CITY OF PORTLAND, MAINE

PLANNING BOARD

July 20th, 2015

Project Name: Jewish Community Center and Preschool/Daycare
Conditional Use and Level III Site Plan
Project #: #2015-058 (Conditional Use and Site Plan)
Address: 1342 Congress Street, Portland
CBL: 191-B016 & 017
Applicant: Jewish Community Alliance of Southern Maine
Planner: Jean Fraser

SITE PLAN

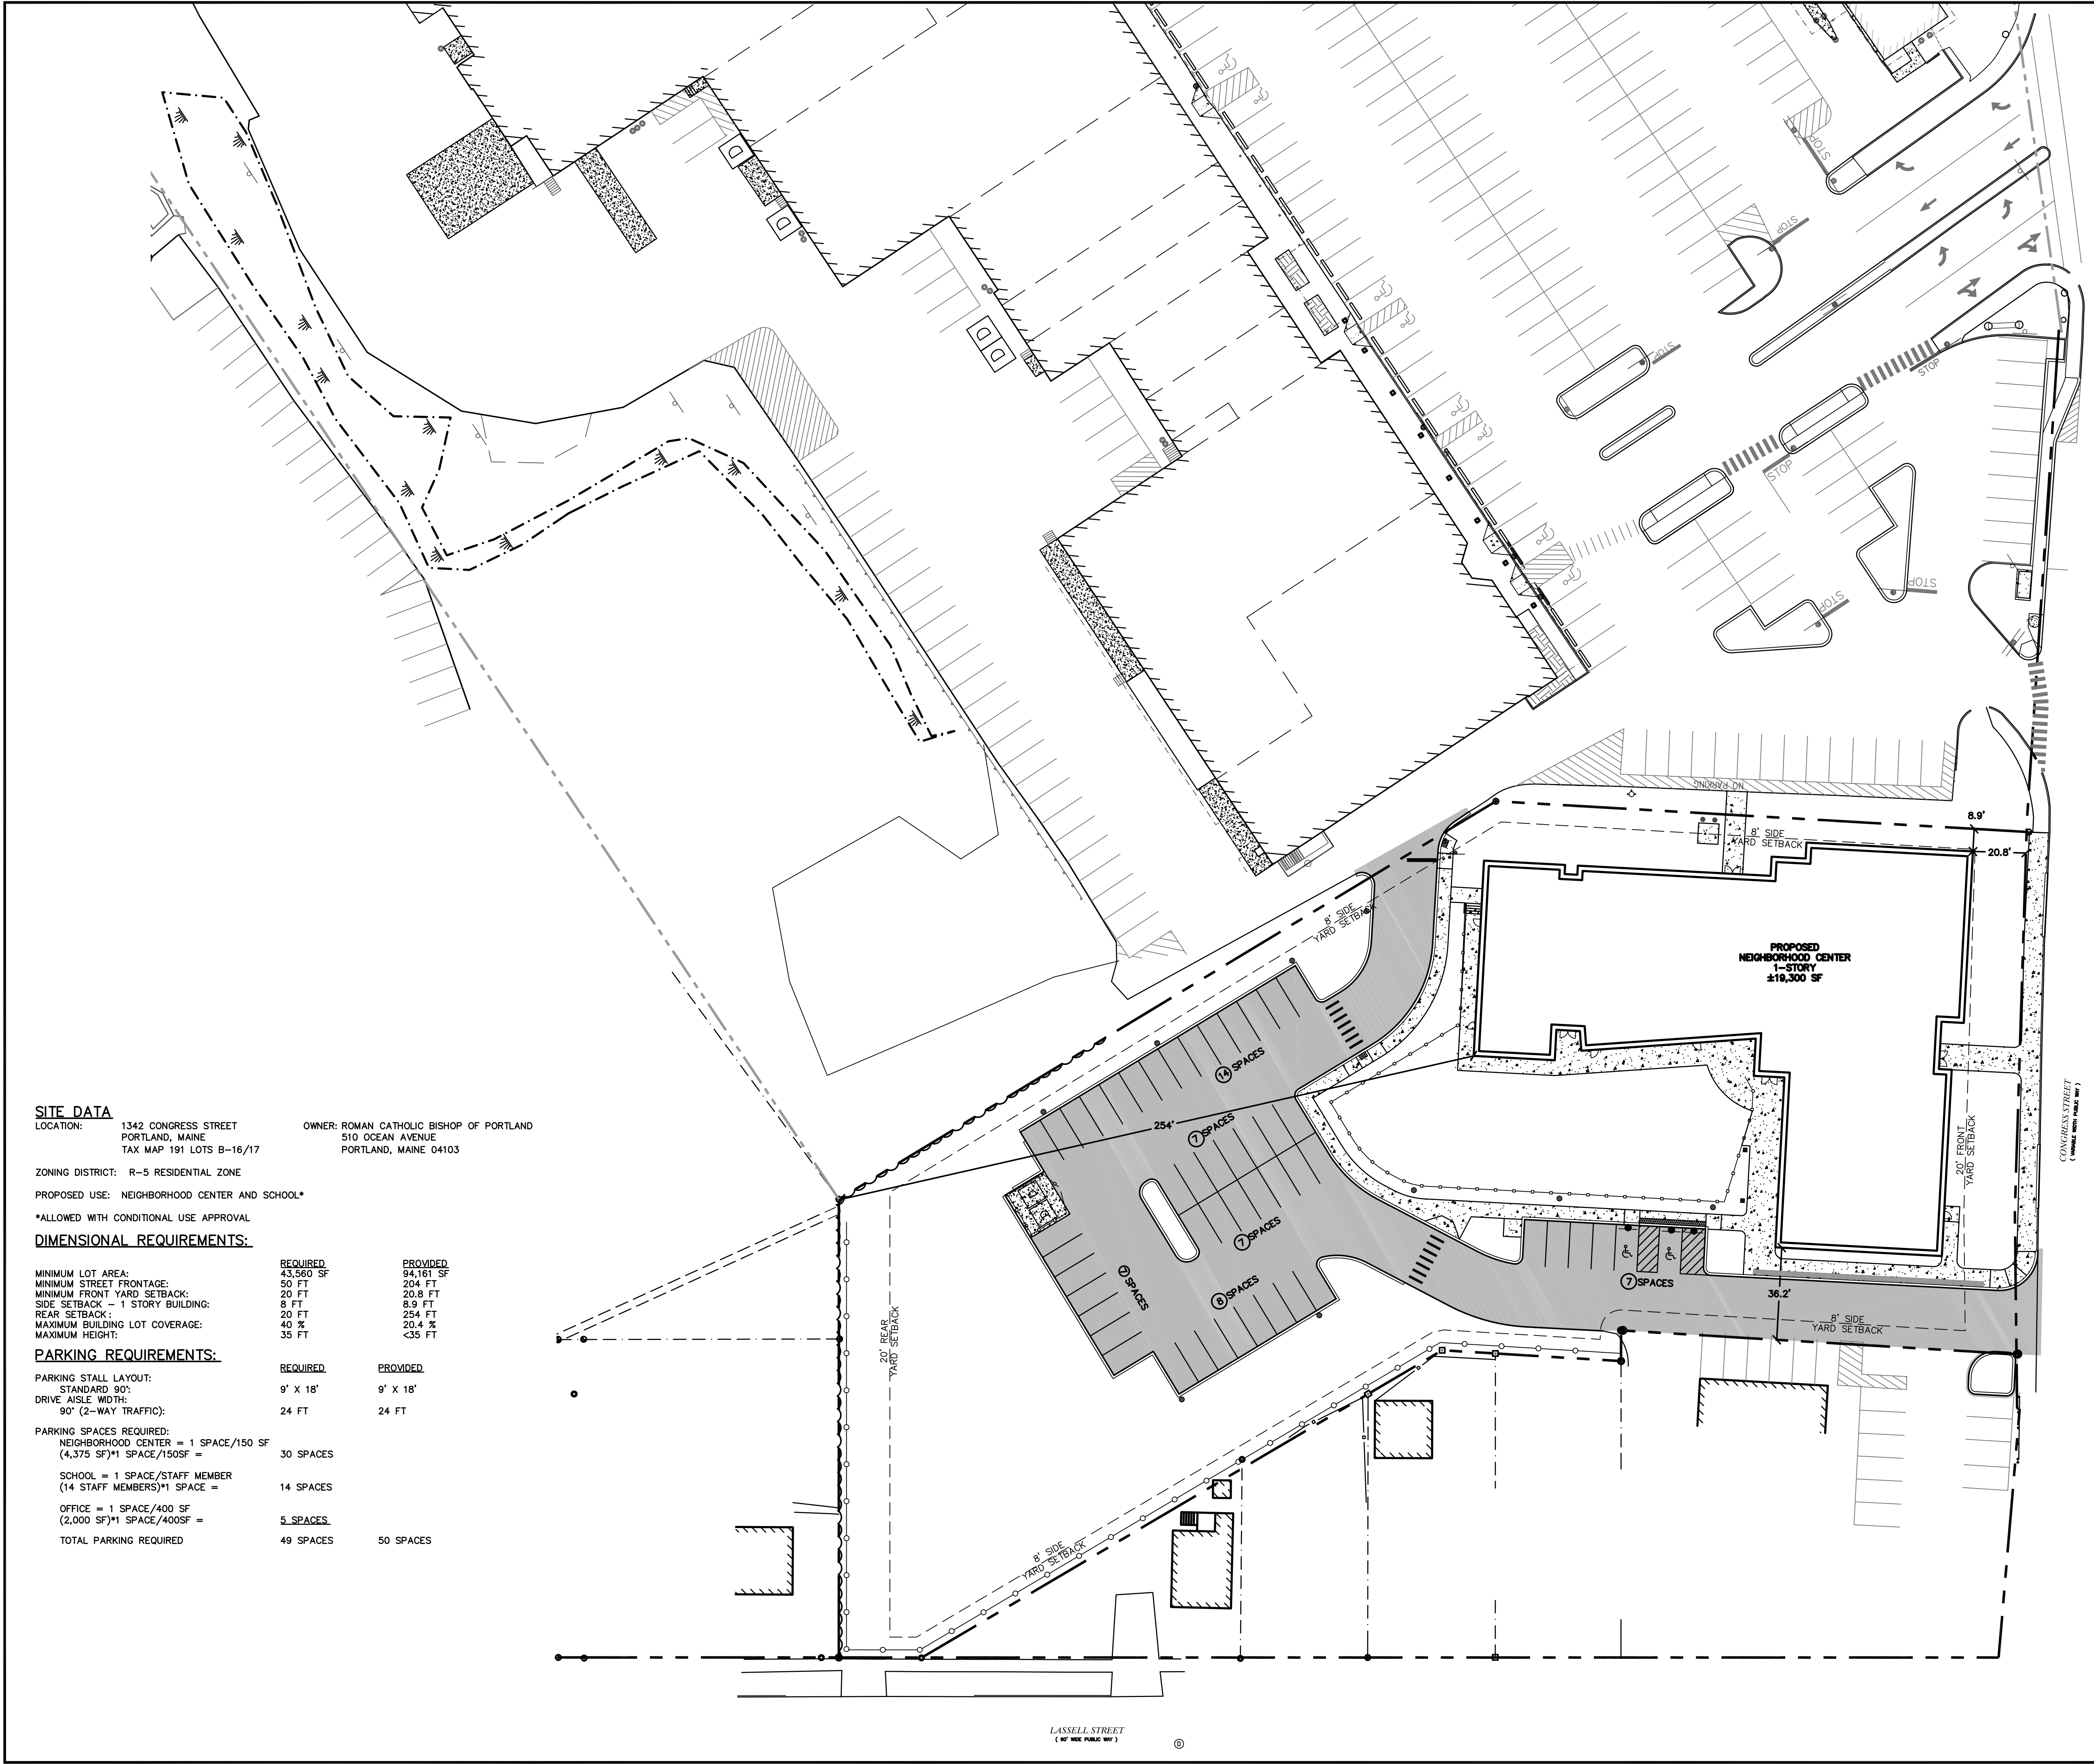
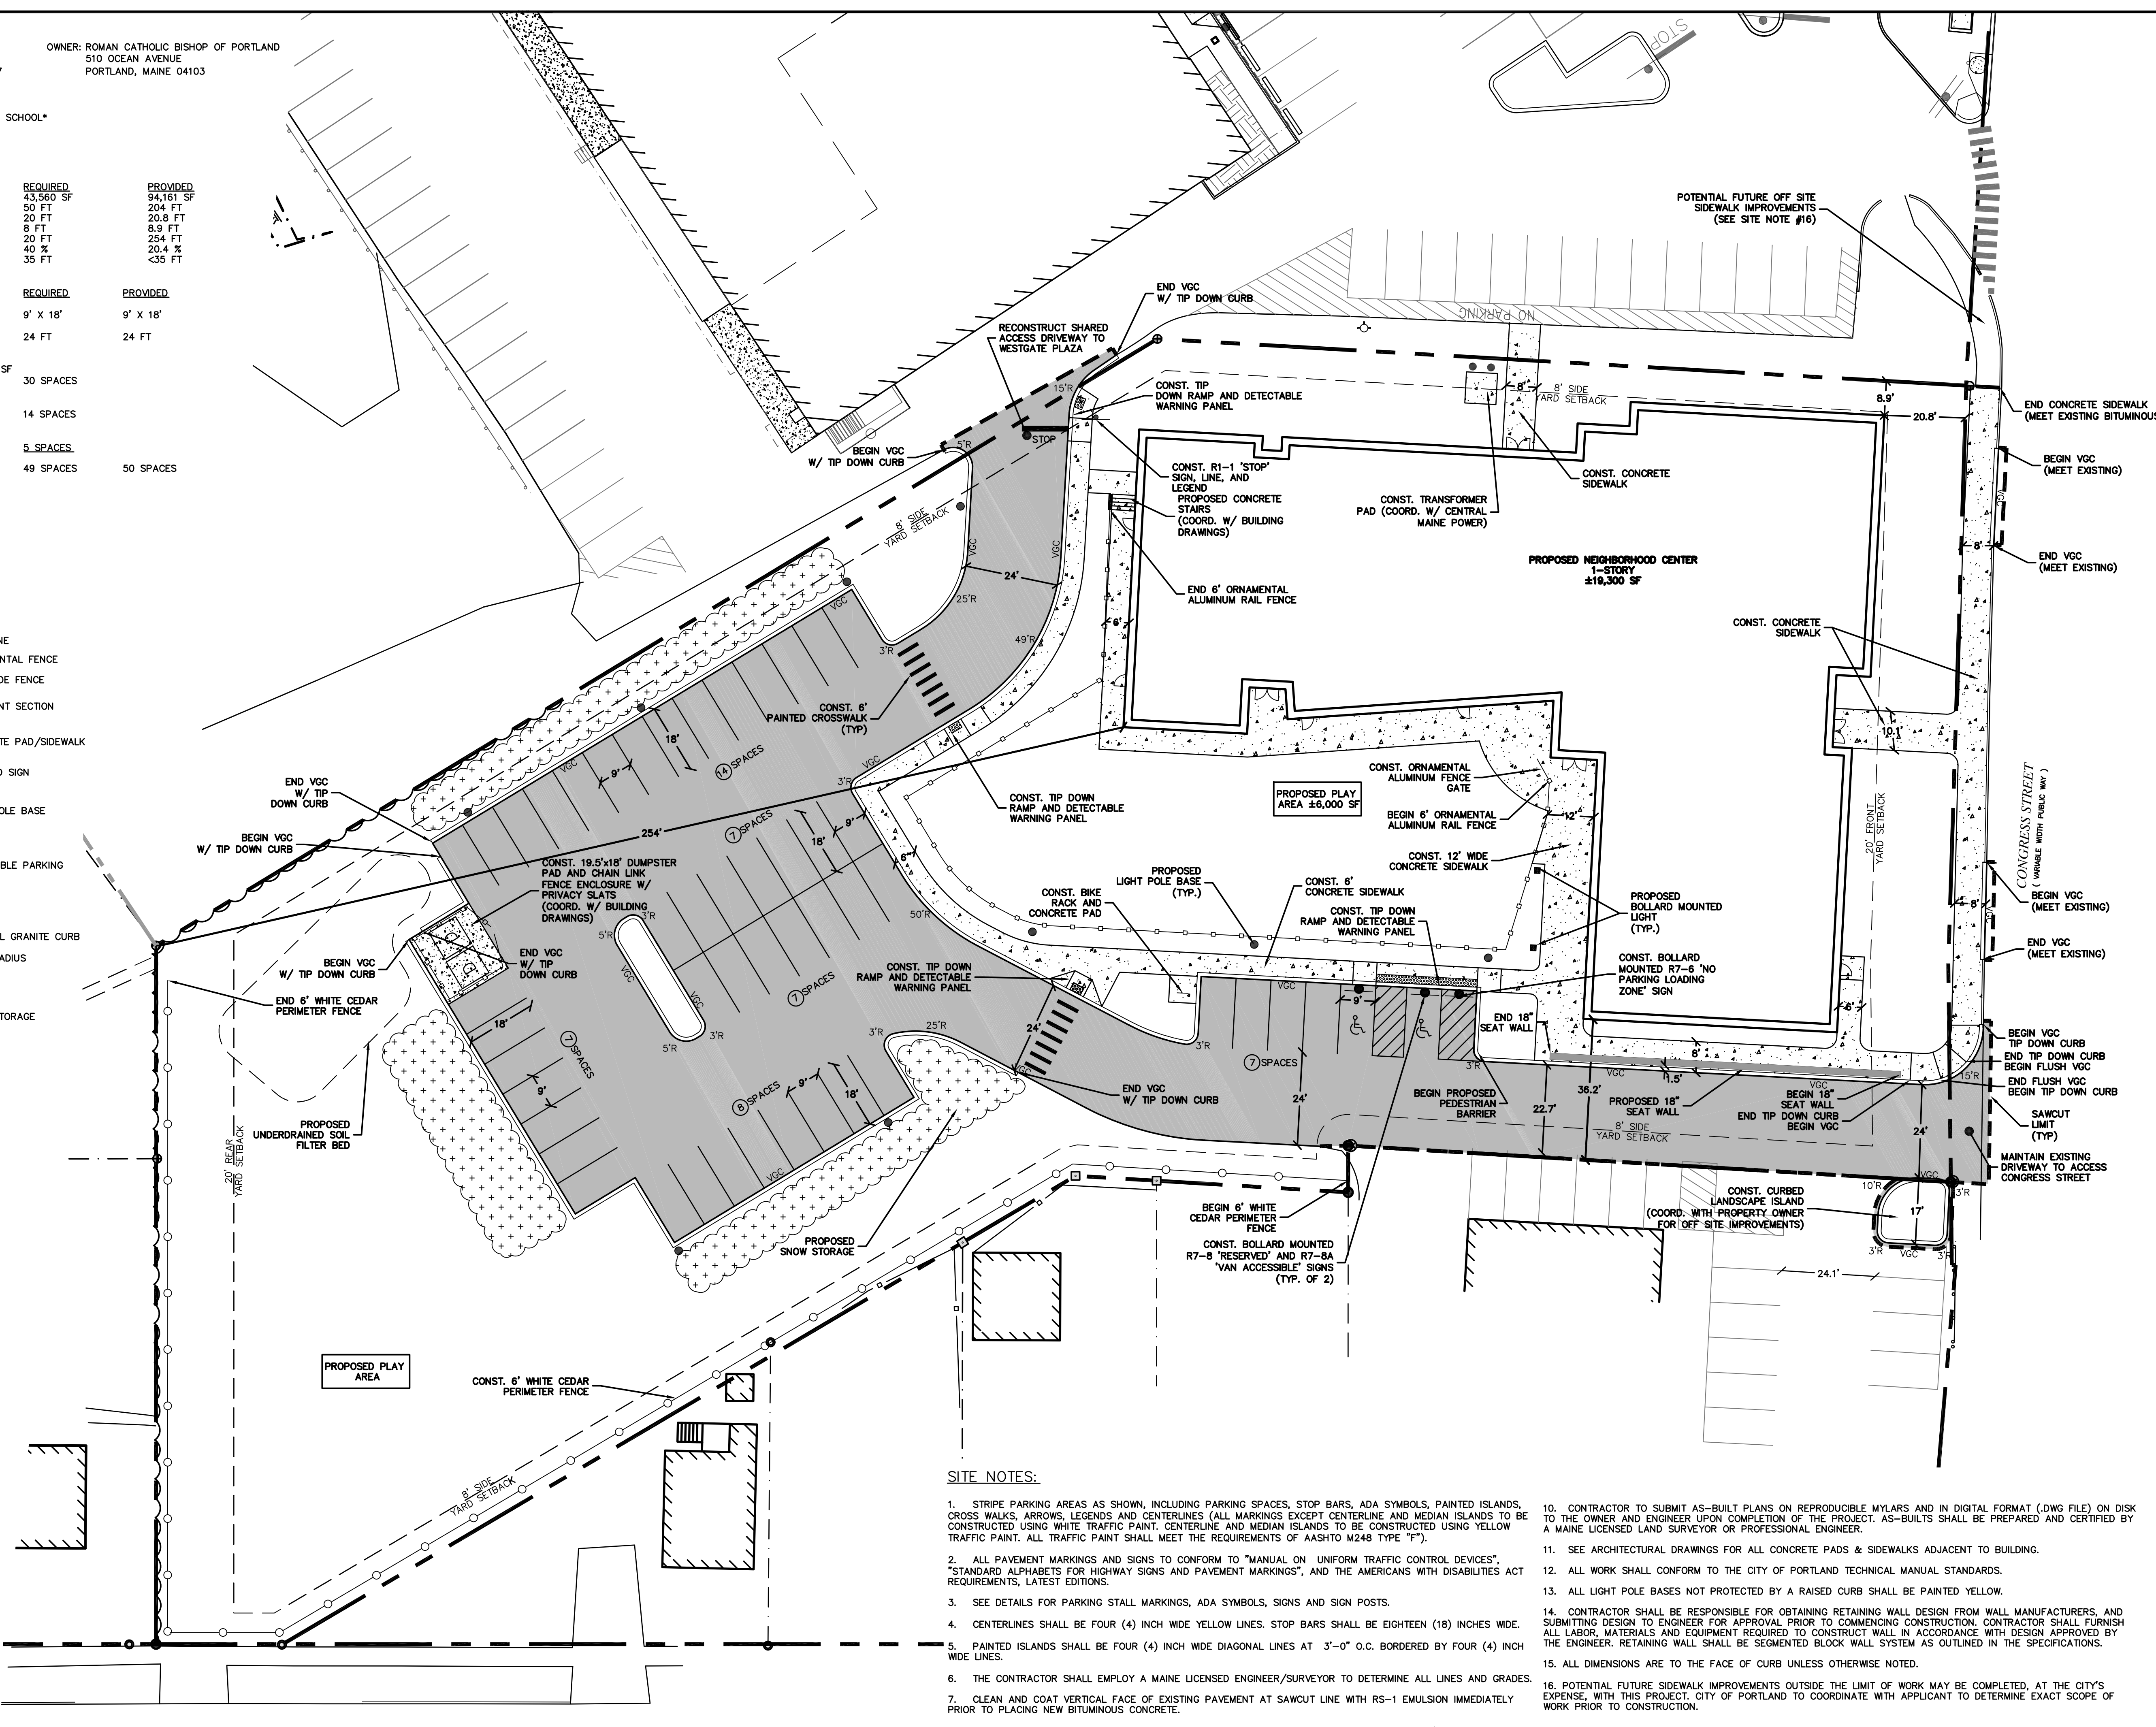
1. **Driveway width:**
The Planning Board voted 6-0 (Morrissette absent) to waive Technical Design Standard Section 1.7.1.3 to allow the proposed driveway to be 22.7 feet wide for one section near Congress Street as shown on the Site Plan in Plan P6;
2. **Soil survey**
The Planning Board voted 6-0 (Morrissette absent) to waive Technical Design Standard Section 7 *Soil Survey Standards* that require a soil survey as the applicant has previously taken soil borings as part of an earlier environmental assessment.

- iii. That the applicant revise the curb ramp layout at Congress Street in accordance with the comments of Tom Errico dated June 26, 2015, with revised plans to be reviewed and approved by the Planning

- iv. That the height of the boundary fence along the eastern boundary and associated buffer treatment be the subject of further discussion with the City Arborist, Planning Authority and nearest neighbor (P Bernard) and any agreed revisions be shown on a revised Site Plan/Landscape Plan for final approval prior to the issuance of a building permit; and

- vi. That additional lighting information shall be submitted in respect of the widened drive access and building entrance nearest to Congress Street to show that the site lighting meets the City Technical Standards, and any deficiencies shall be addressed in a revised lighting plan for review and approval prior to the issuance of a building permit; and

- The driveway entering the site from Congress Street is noted as having a width of 22.7 feet. This width (in the area where parking maneuvers occur) does not meet City standards and thus a formal waiver should be requested by the applicant.

Status: The curb ramp layout should be revised so that the ramp flare does not impact accessibility along the sidewalk route. Having a tip-down design will help to address this issue.

Status: I find the proposed driveway width to be acceptable given that most vehicles will be passenger cars and that a secondary driveway via the Westgate Shopping Center will be provided. I support this waiver request.
